LAND NORTH OF WATER LANE, ANGMERING - DISCHARGE OF PLANNING CONDITION 5

On behalf of Cala Homes, please find enclosed documentation to help discharge planning condition 5 pursuant to planning permission A/88/24/s73

Condition 5

NORTHERN NOISE BUND
CATCHMENT AREA

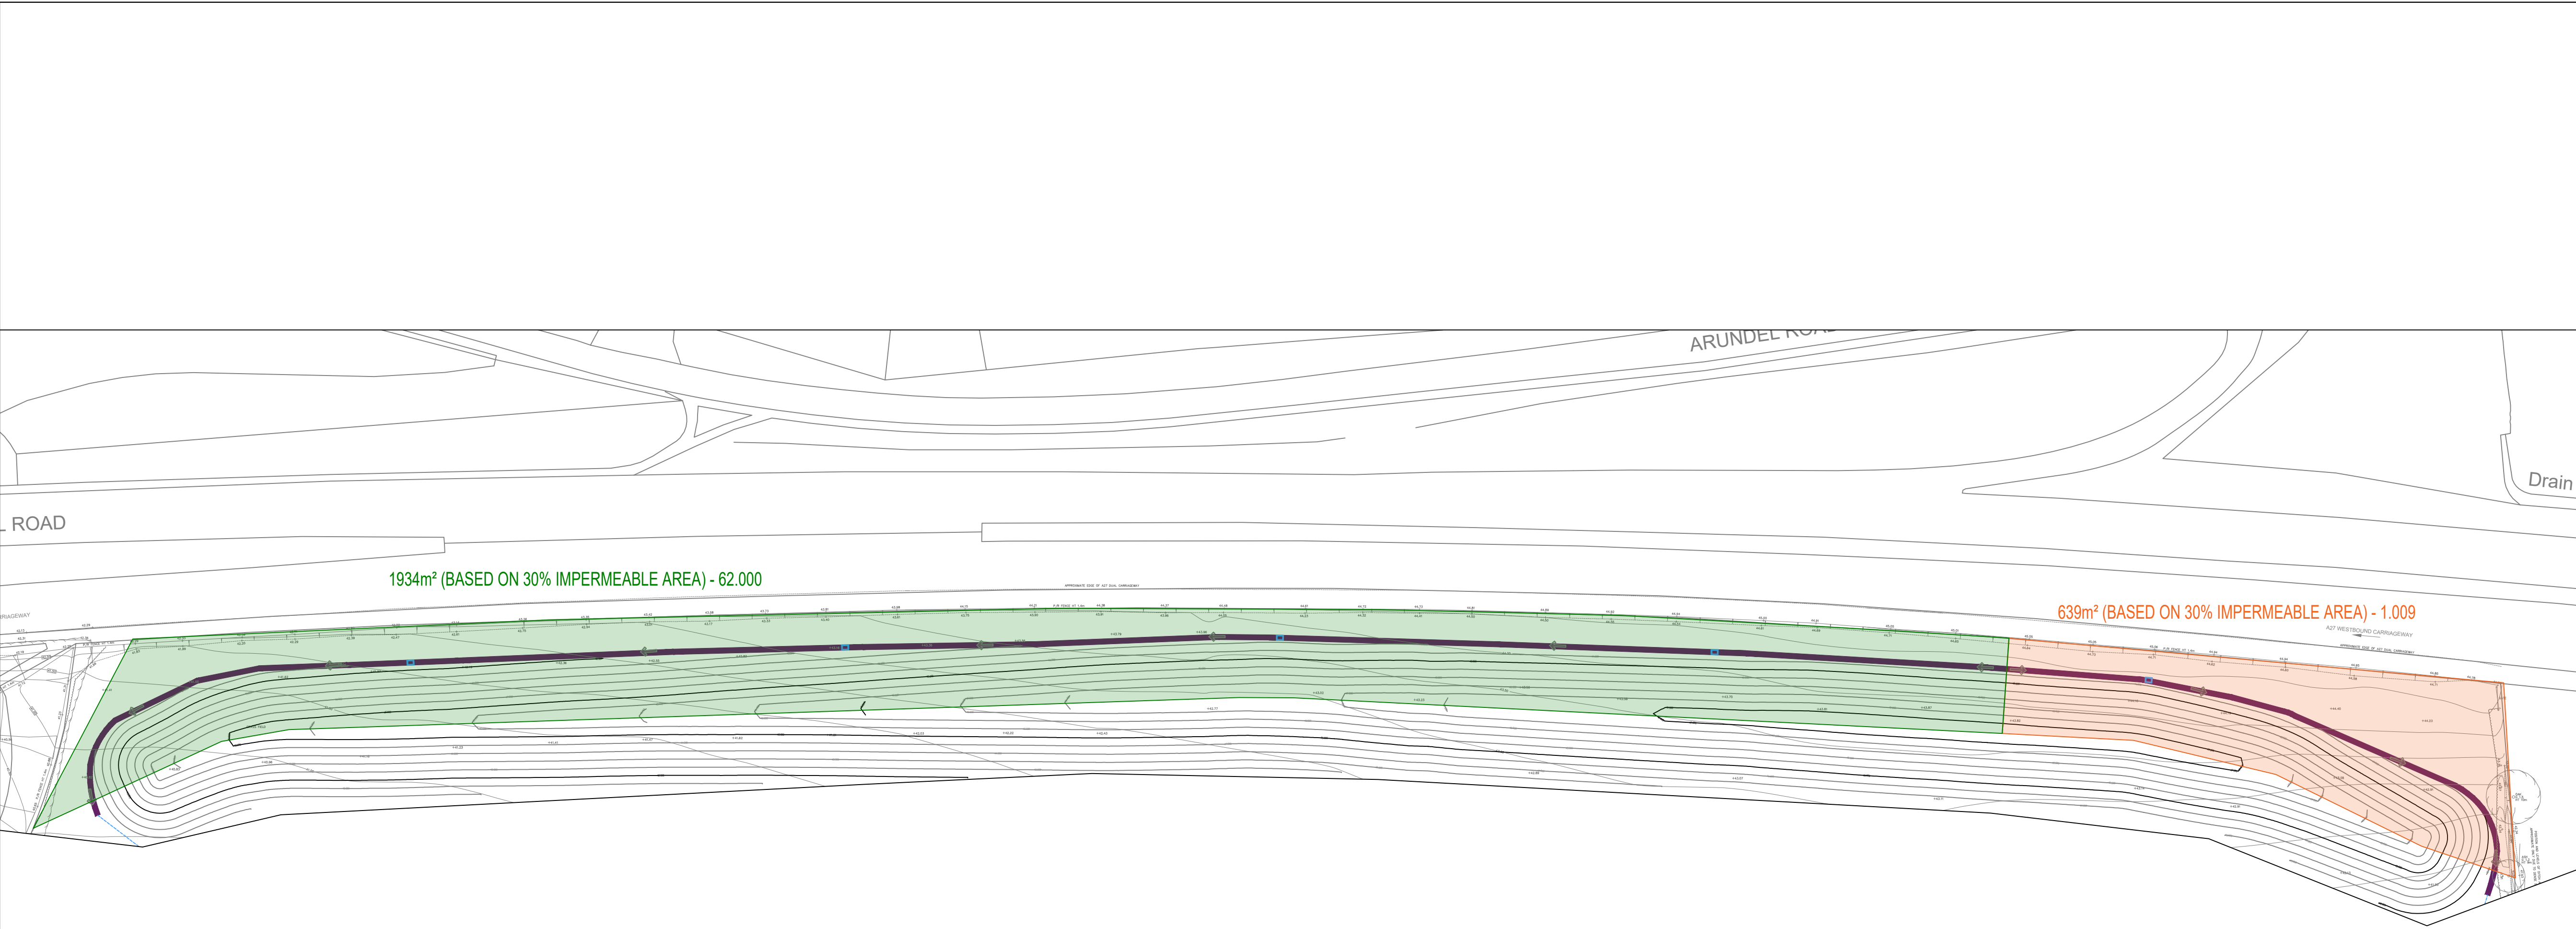
Point 2 – Capacity Calculations for Filter Drain and Swale

Drainage calculations enclosed for northern bund area.

Catchment Area Plan provided to show which area of the bund each calculation relates too.

The surface water from the swale is proposed to connect into the Phase 2 drainage network. No infiltration is proposed.
